Your Ref
TR030006
Our Ref
ADW/ADW/124645.0013
Date
28 October 2021

**Able Marine Energy Park Material Change 2
Alternative construction plans**

Accompanying this letter is a pair of plans showing the potential revised construction sequence, which the Applicant would wish to be an alternative construction sequence. As this would be different to the sequence plans in the material change application this would require an amendment to the amending DCO, namely:

Project: (TR030006) ABLE Marine Energy Park  
 Client: ABLE UK Limited  
 Drawing Title: Indicative Sequence Plan View 2/3

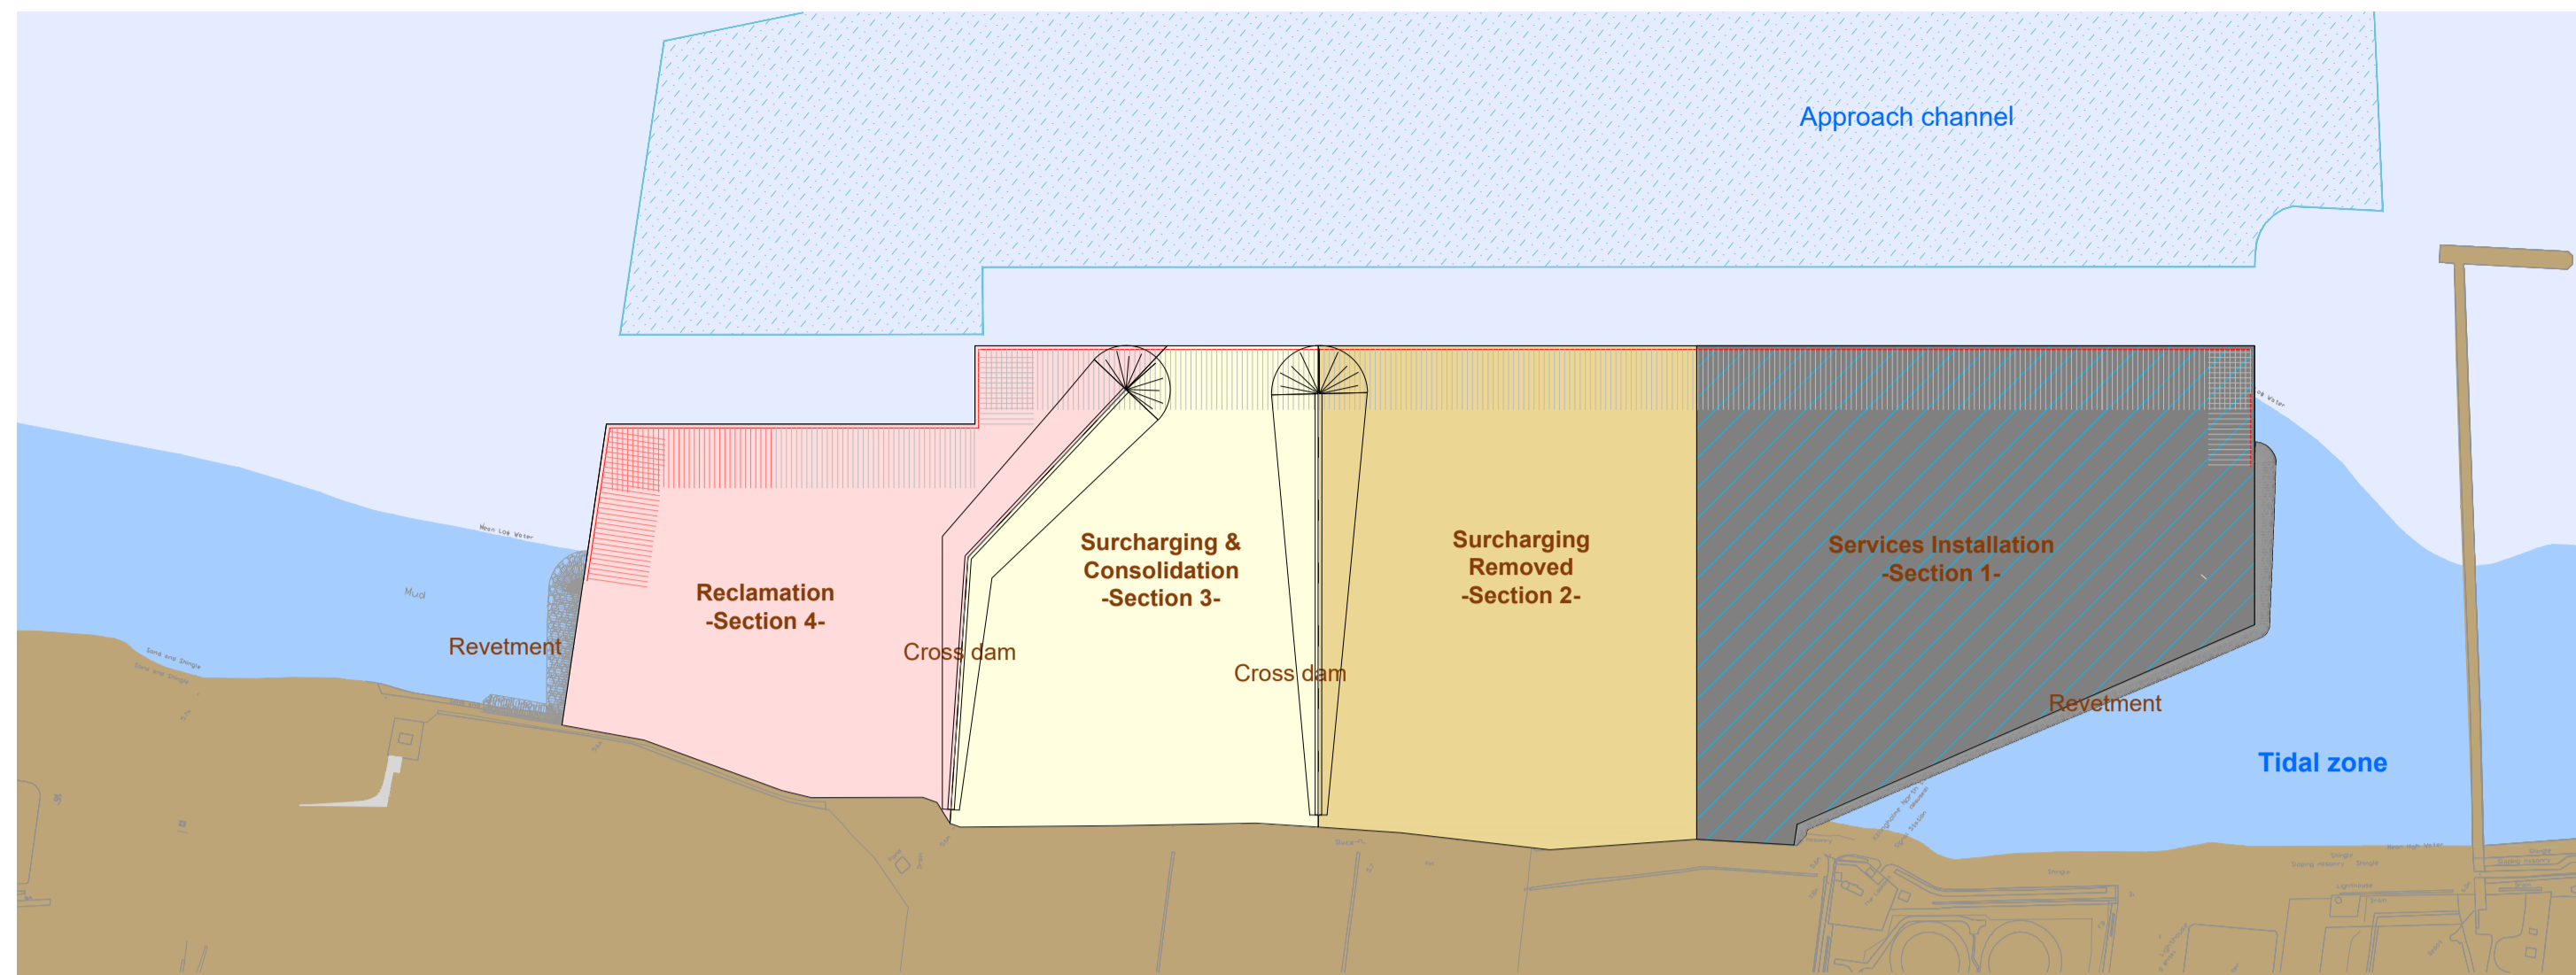
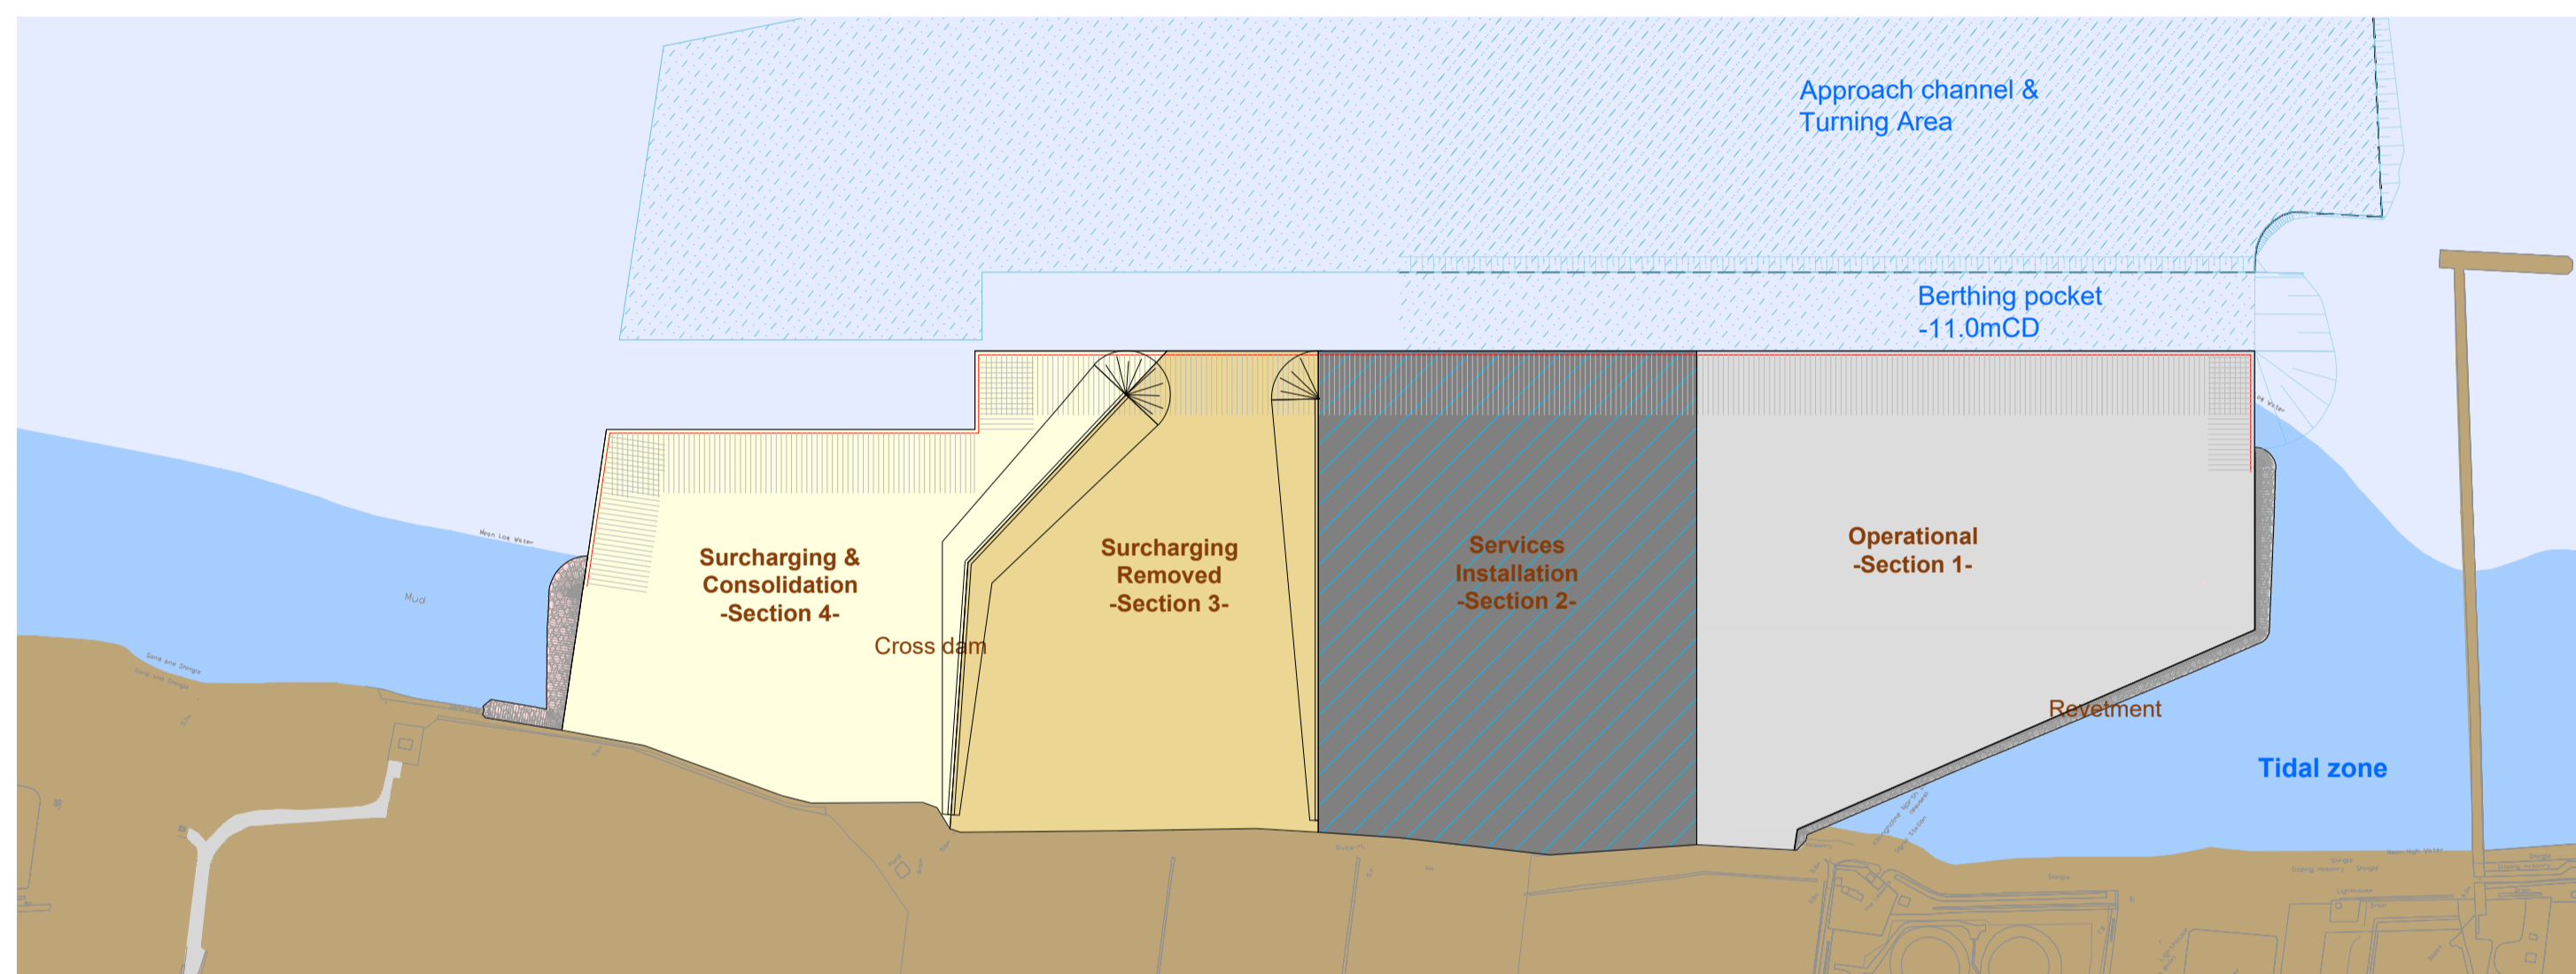
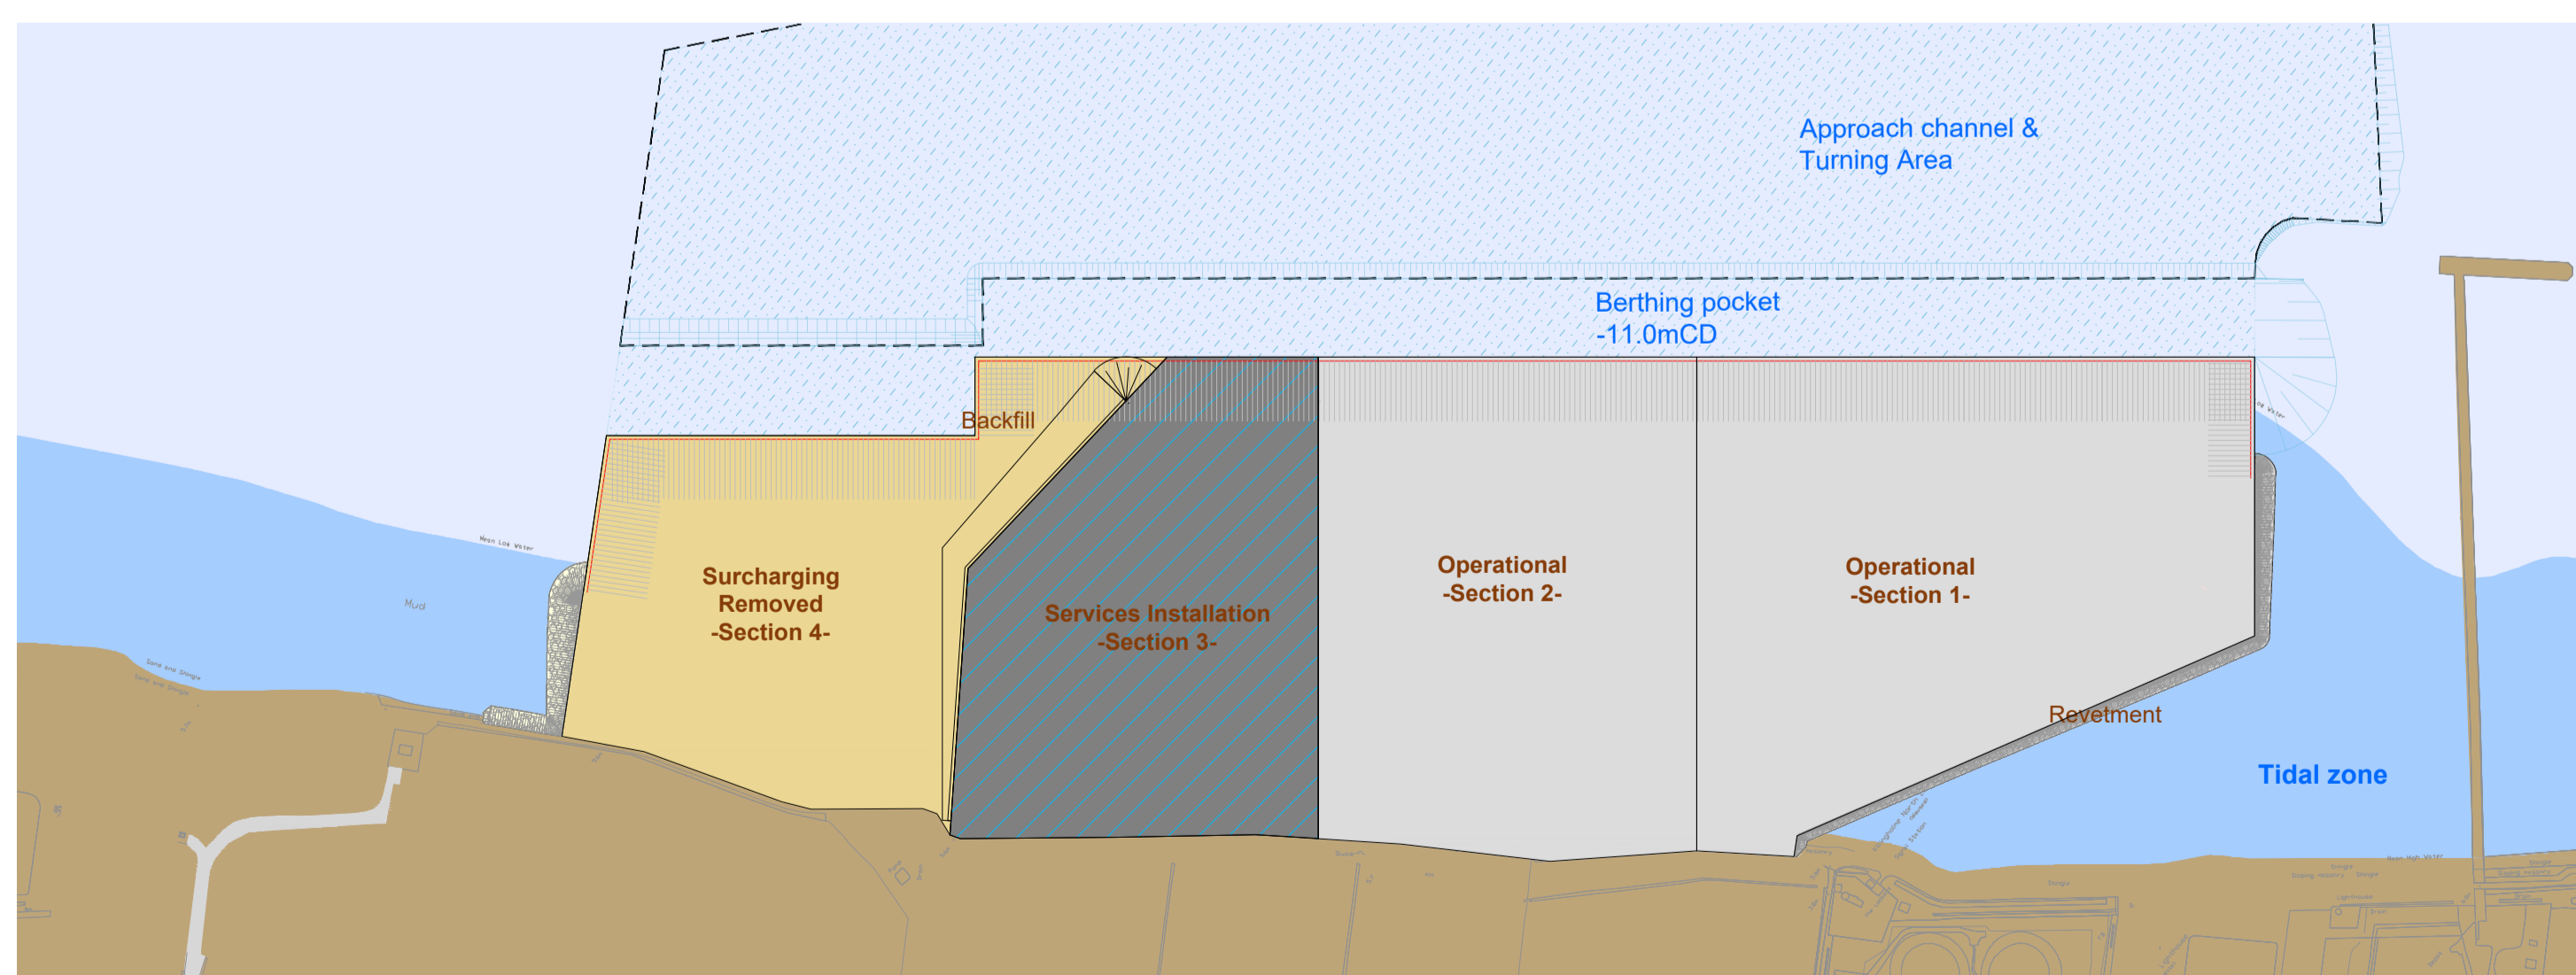
The original construction sequence was to build the quay from north to south; the material change proposes reversing this to build the quay from south to north. A variation on both of these has been proposed, namely building the revetment at the north first, and then building the quay from south to north, starting with a revetment at the south. This would mean that the specialist equipment needed to build the revetments would only need to be mobilised and used for one period at the start rather than being re-mobilised to build the northern revetment later.

- in article 2(5)(p) "AME-036-10010 (Rev C)" becomes "AME-036-10010 (Rev C) or AME-036-10010 (Rev D)"
